WEST SUSSEX COUNTY COUNCIL CONSULTATION

TO:	Arun District Council FAO: Hebe Smith
FROM:	WSSC – Highways Authority
DATE:	21 May 2026
LOCATION:	8-10 Clifton Road Littlehampton BN17 5AS
SUBJECT:	LU/99/26/PL New fixed external seating. This application is in CIL Zone 4 (Zero Rated) as other development.
DATE OF SITE VISIT:	n/a
RECOMMENDATION:	More Information

This application is for new fixed external seating. The site is located on Clifton Road, an un-classified road subject to a speed limit of 30mph.

Site Location and Block Plan

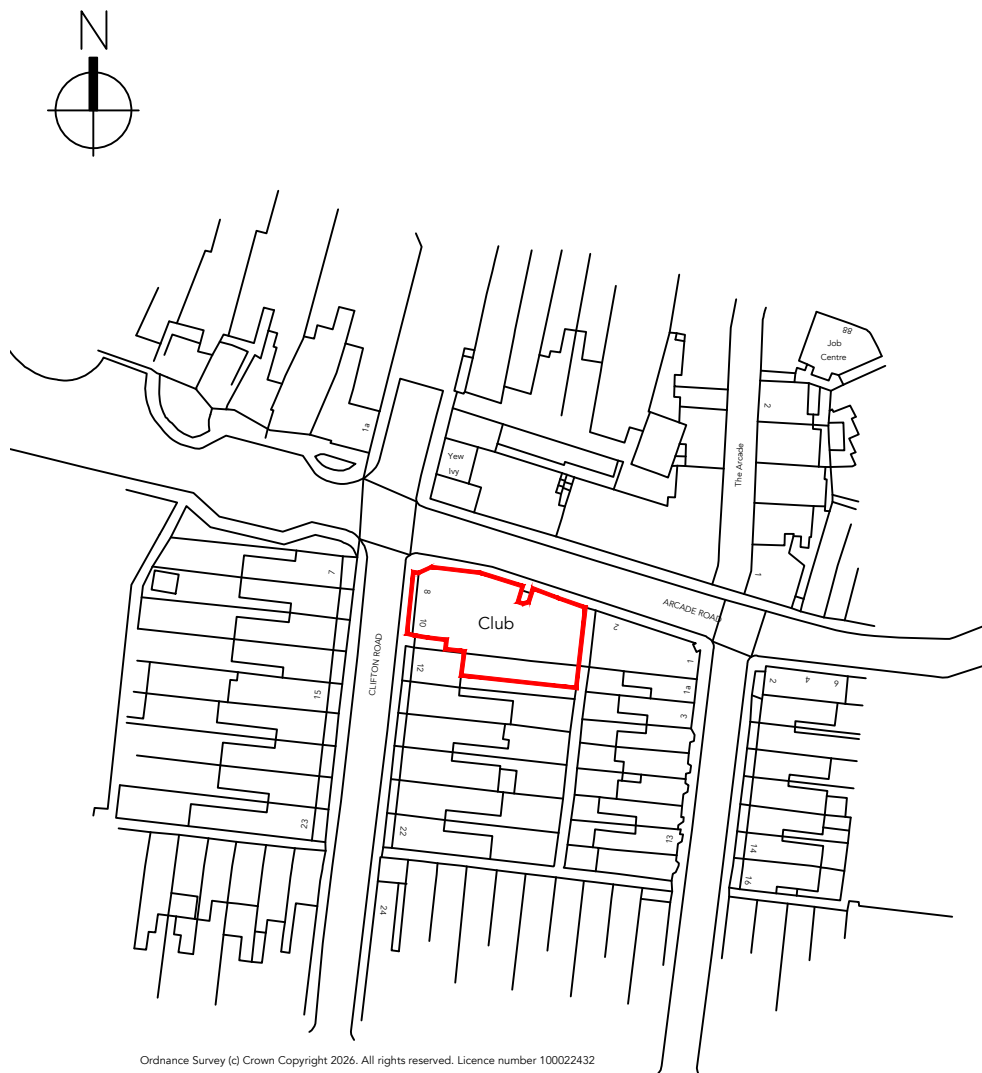
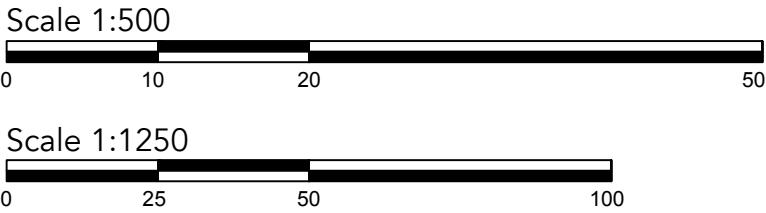
The proposed external seating area would serve the existing public house and is proposed to be placed within land considered to be public highway. The application documents indicate that the proposed seating area would be subject to a pavement licence. The pavement licence permits temporary structures, including seating, to be placed within the public highway for a fixed period. The LHA advise that the proposed 'fixed' nature of the external seating would result in a permanent obstruction to the public highway and would not be permitted under a pavement licence.

Measurements have not been provided on the proposed plans to demonstrate the retained width of the public highway. The applicant is requested to provide a plan demonstrating the proposed seating area in relation to the existing and proposed footway width, in order for the LHA to assess whether sufficient footway width will be retained for public use.

In order for the fixed seating to be acceptable, the highways rights would need to be formally removed by way of a Stopping Up Order. This is controlled by Section 247 of Town and Country Planning Act and would be subject to a separate process administered by the Department for Transport's National Casework Team. The Highway Authority along with other statutory undertakers and interested parties would be consultees in this process. There is also no guarantee that this process would be successful. The comments made here would not constitute the Highway Authority's formal position regarding any future Stopping Up.

Alternatively, the applicant may wish to consider providing removable seating to fall within the requirements of a pavement licence.
